10th February 2021

RE: OBJECTION TO ERECTION OF EXTENSIONS AND ALTERATIONS TO EXISTING COACH HOUSE TO FORM ANNEXE ACCOMMODATION ASSOCIATED WITH COACHWAYS, 1A DINGLEY ROAD, EDGERTON, HUDDERSFIELD, HD3 3AY AND PARTIAL DEMOLITION OF EXISTING BUNGALOW WITH RE-BUILD TO FORM 2 STOREY DWELLING (WITHIN A CONSERVATION AREA)

LPA REF: 2021/90126

Proposed Site Layout

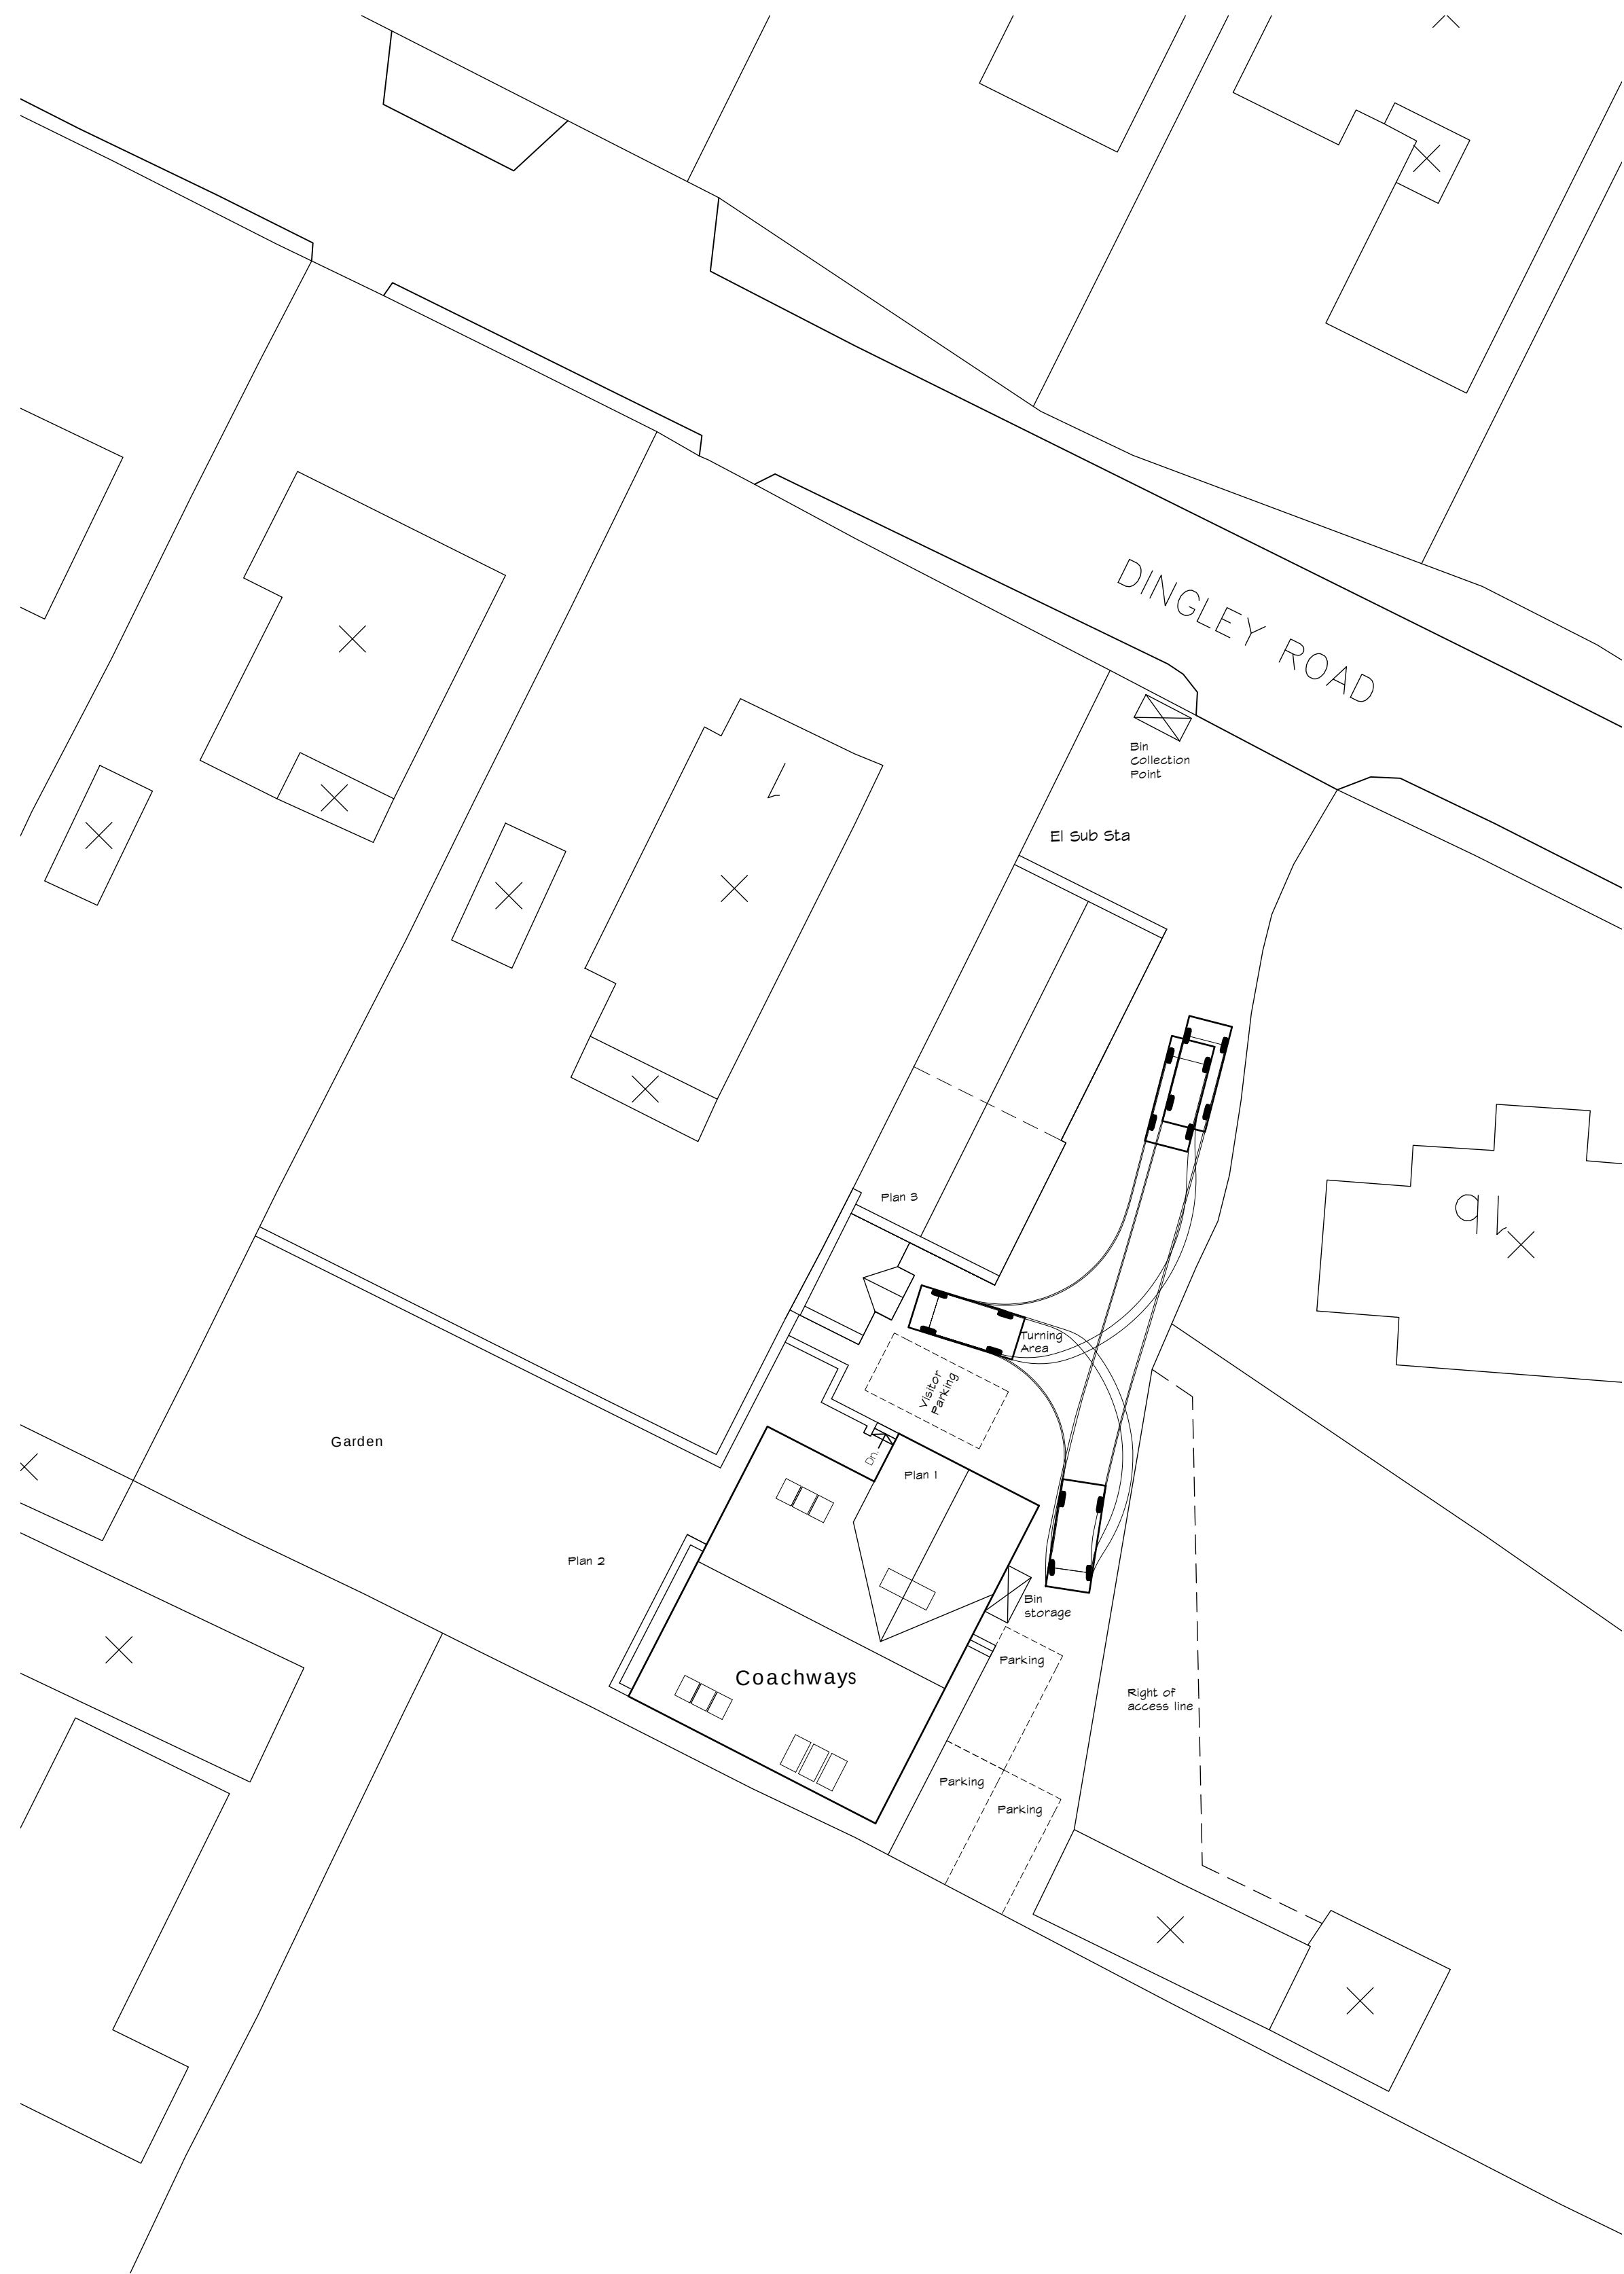
The application proposes four car parking spaces. Two spaces are proposed in front of the 'annexe' and two spaces are proposed, in tandem, at the side of the main house.

Only two spaces are proposed for the new 4-bed dwelling, which is lower than the recommended three spaces. Whilst only one space is recommended for 1-2 bedroom *apartments*, the 'annexe' is proposed as one bedroomed house not an apartment and therefore justifies two spaces in our opinion. The total number of four spaces proposed is therefore insufficient (it needs to be five) and moreover, there is no visitor parking provision. It is felt that the development should include at least one space for visitor parking given that the existing drive would serve four dwellings (the fourth dwelling being 12 Thornhill Road, which also has a legal right of access to its rear). The proposals as they stand would result in visitors parking on Dingley Road, which is a narrow road with substandard footways and does not meet modern standards. Any displacement of parking onto the highway would therefore be detrimental to the free and safe use of Dingley Road.

Our clients are equally concerned that the four car parking spaces proposed would not be able to operate properly within the confines of the land owned and as a result, the proposals would again have a detrimental impact on highway safety.

As can be seen from the location plan and the proposed layout plan when viewed together, the red line boundary forms a line directly from the corner of the first of the tandem parking spaces to the

corner of 1B Dingley Road. This means that there is no turning space for any of the proposed parking spaces when the spaces are fully occupied, meaning that cars would either have to reverse all the way up the drive from Dingley Road, or reverse all the way down the drive to Dingley Road, a length of approximately 32m.

The parking proposals and lack of internal turning space would therefore potentially result in accidents occurring between cars entering/exiting the drive and pedestrians and vehicles using Dingley Road, and between cars entering/exiting the drive and the residents of 1B Dingley Road (our clients), as they share the drive and access with the applicant. It should be noted that our clients land cannot be used as a turning area.
